13 July 2017

**Re: Mortdale SSD 7421 Response to Submissions**

Skylife Properties Pty Ltd has prepared a response to an email from the Department of Planning and Environment (DP&E) dated 28 June 2017 seeking clarification on matters raised by agencies relating to the Mortdale RTS from:

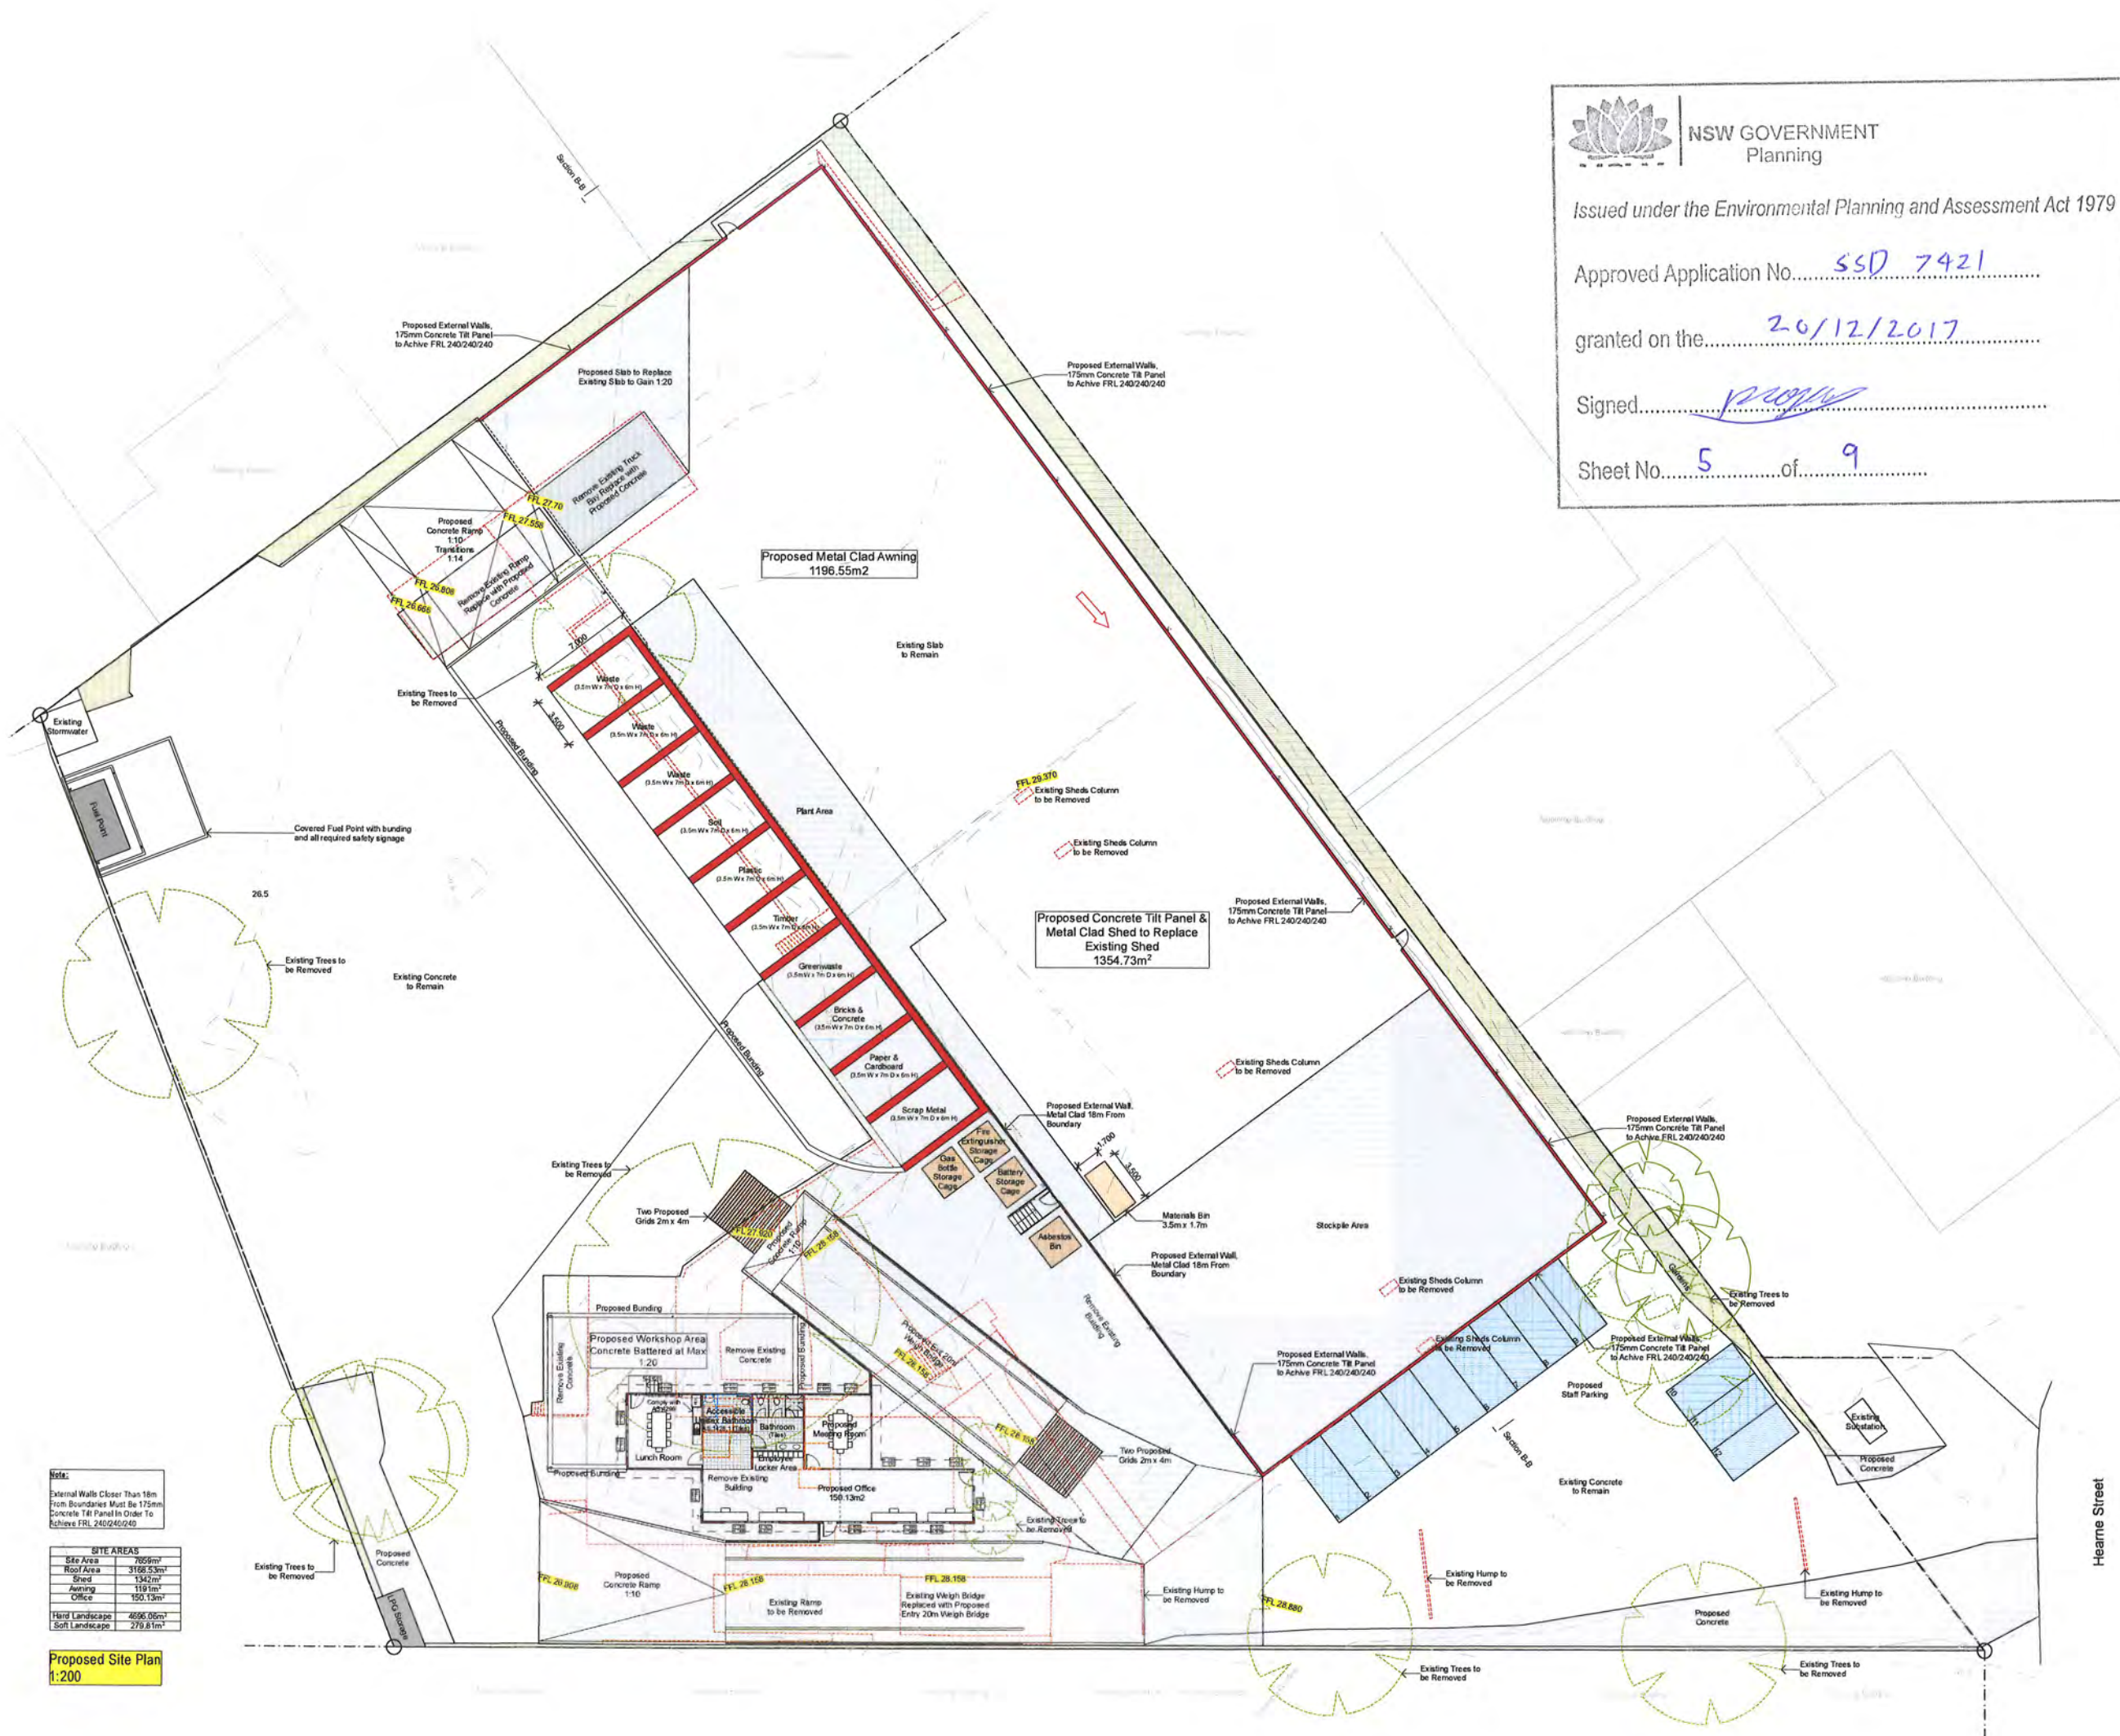
Stockpiles of finished products are to be stored in the processed material storage bays on the lower deck to a height of 6 metres. The Department has two concerns regarding this:

- From the diagrams provided, the design of the storage bays is such that they cannot contain a 6m high pile of waste material within. The dividing walls appear to be less than 6m high and the upper deck retaining wall (that forms the back wall of the bays) is quite low. Therefore, waste stacked to 6m could escape from the bays from all sides.
- In addition, Tables 3 and 4 of the RTS assume that the stockpiles could be fully stacked to 6m high and are thereby able to store 147m<sup>3</sup> of material each. Unless the stockpiles are fully enclosed in boxes filled to the brim, this is not practically achievable. It would therefore seem that the stockpile capacity of the site has been overestimated and should be revised.

If glass and plasterboard are to be recovered from the incoming waste stream, details must be provided regarding the suitability of the location of the skip bin, frequency of collection, and anticipated annual tonnage. Due to the restricted size of the site, it should be demonstrated that the bin and collection thereof will not conflict with traffic onsite. Details should also be provided regarding how glass and plasterboard are separated from the incoming stream and how they are transferred to the skip bins. If other 'minor' waste streams are to be recovered, the same information should also be supplied for them. The process flowchart should also be updated.

- The architectural plans at **Appendix A** have been updated to reflect:
  - the dimensions of the storage bays at 3.5m wide X 7m depth X 6m high = 147m<sup>3</sup> (**Figure 1**);
  - plant area (**Figure 2**); and
  - a materials bin within the shed for plasterboard (**Figure 2**).

- b. Updated stockpile volumes have been calculated by reducing the total storage of each storage bay by approximately 30% as reflected in **Table 1 and 2** below. This reduction is considered conservative.

Glass will not be recovered. Plasterboard will be placed in a separate materials bin as identified on the updated architectural plans.
